Subject: Consultation Response 2023/93503 RE: Roslyn Avenue, Netherton

Glyn Davies | Senior Archaeological Officer

TITLE: PROPOSED SITE LAYOUT

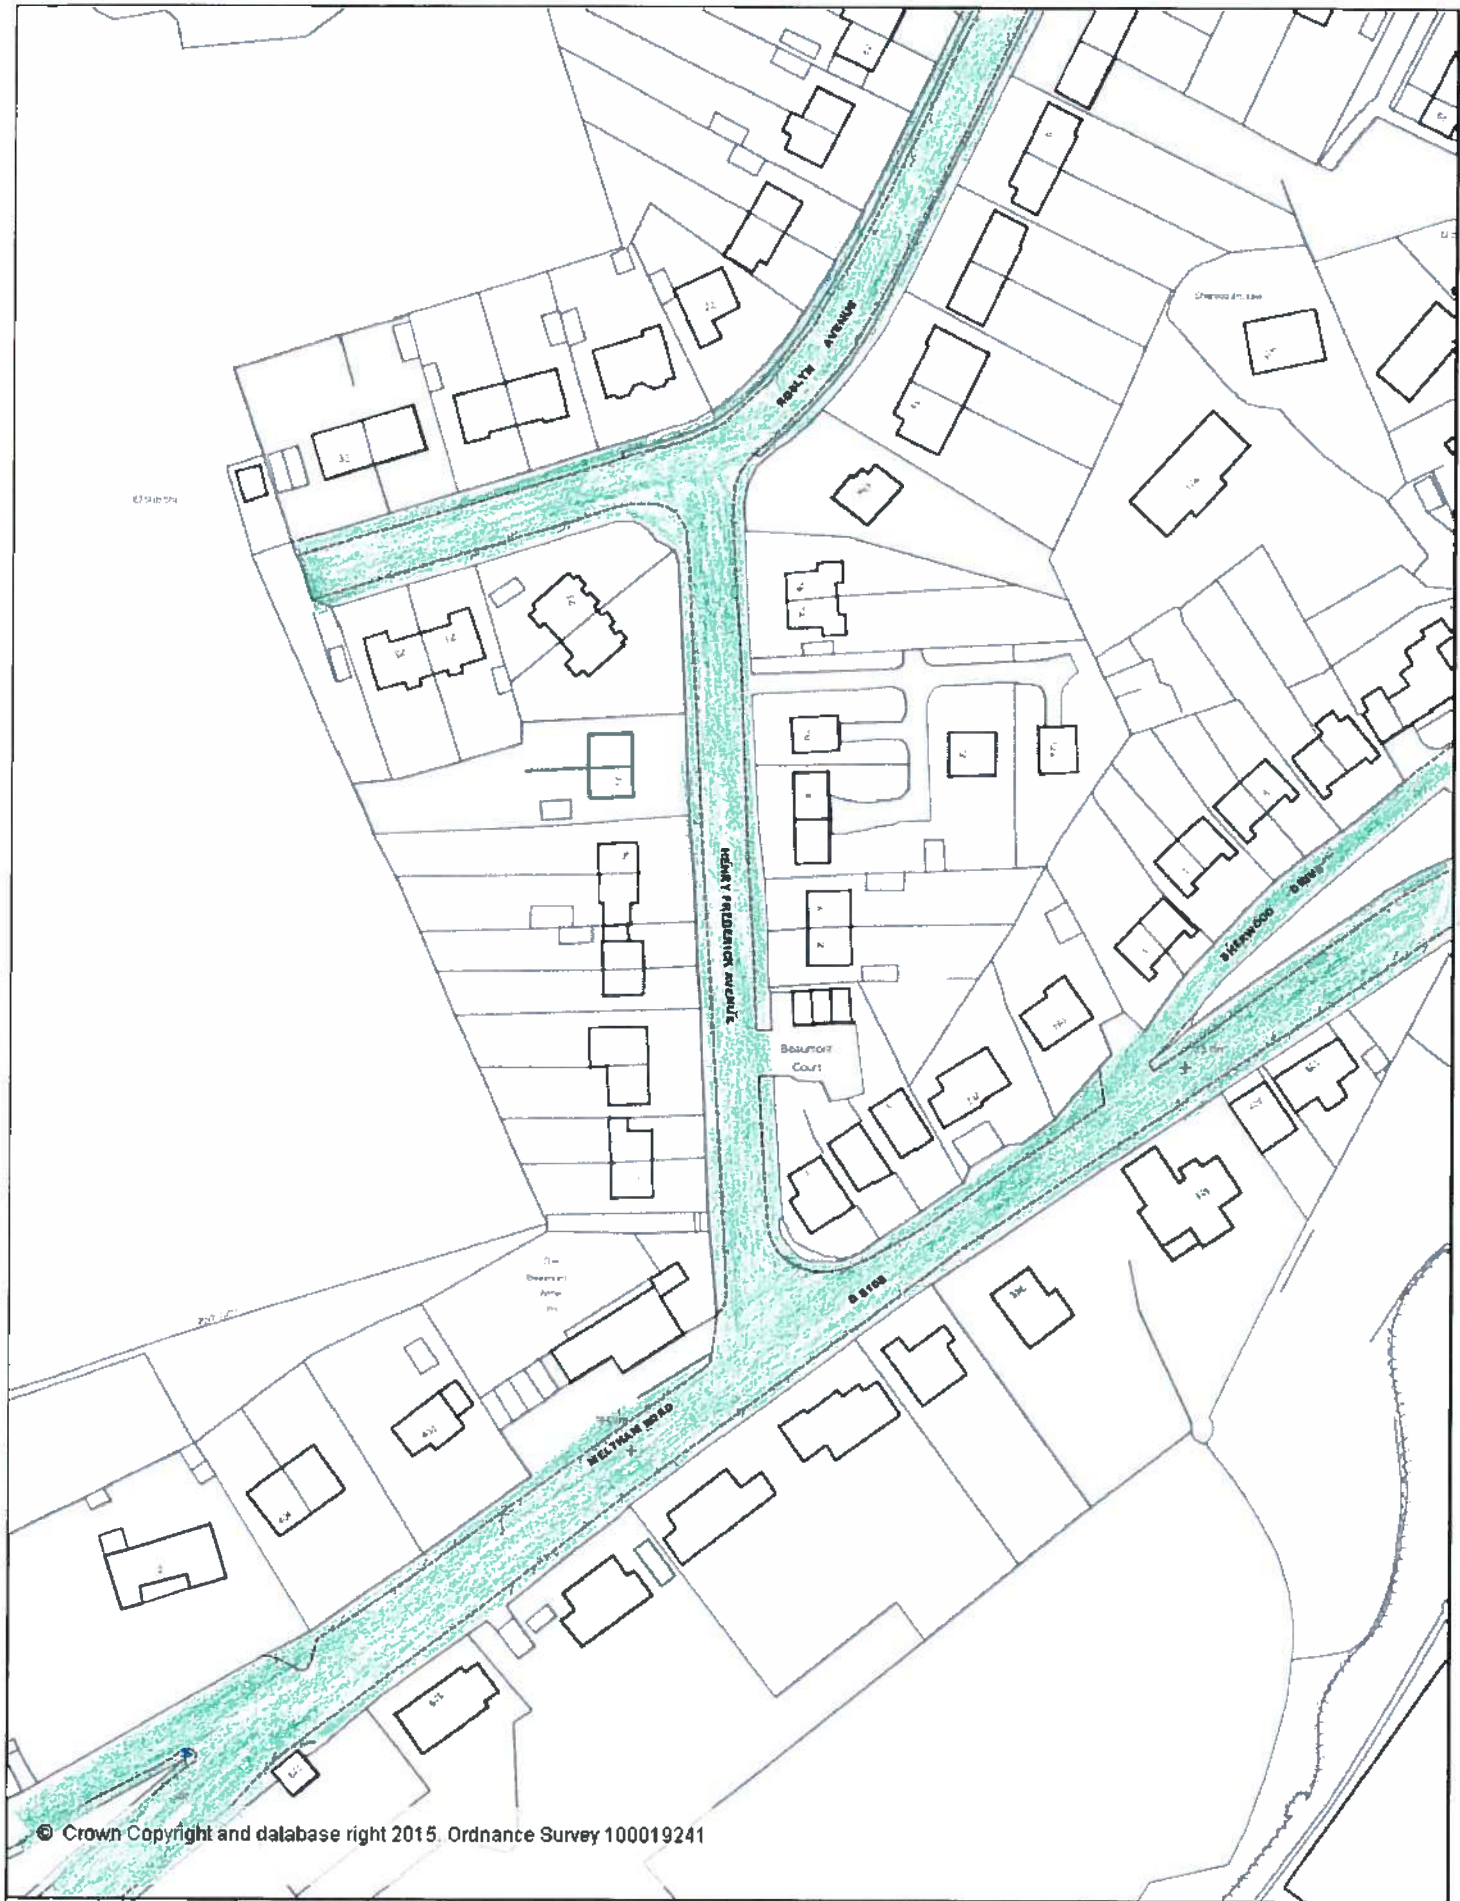
I have looked through the information you have sent me, the draft report and some of the illustrations. Based on this the only significant archaeological feature that was identified by the evaluation works is the enclosure in the south east corner of the site. This feature is still of unknown date and therefore of unknown significance. The proposed development aims to avoid this area with the proposed houses although a road will cut across or near the edge of the feature. In addition, a play area will be constructed within the area of the enclosure.

The impact of the road associated groundworks and groundworks related to the play area will depend on the significance of the ditched enclosure which is dependent on its date and the nature of any features within the enclosure which have not as yet been determined. The other factor will be the depth of disturbance related to any groundworks that take place in the enclosure or close to it. If such groundworks are restricted to topsoil depth then the impact will be low but should any groundworks extend below topsoil depth then the impact will be greater possibly major.

The impact of the works in the vicinity of the enclosure ditch or interior is thus uncertain until the enclosure is dated. In light of this I would recommend that a programme of archaeological recording is required within the enclosure area, and for 10m around it. The programme of works for any ground works that extend down to the base of the topsoil or deeper should comprise a watching brief with provision for strip, map and sample excavation where any archaeological features are identified.

"No development to take place within the area indicated until the applicant, or their agents or successors in title, has secured the implementation of a programme of archaeological recording. This recording must be carried out by an appropriately qualified and experienced archaeological organisation or consultant, in accordance with a written scheme of investigation which has been submitted by the applicant and approved in writing by the Local Planning Authority."
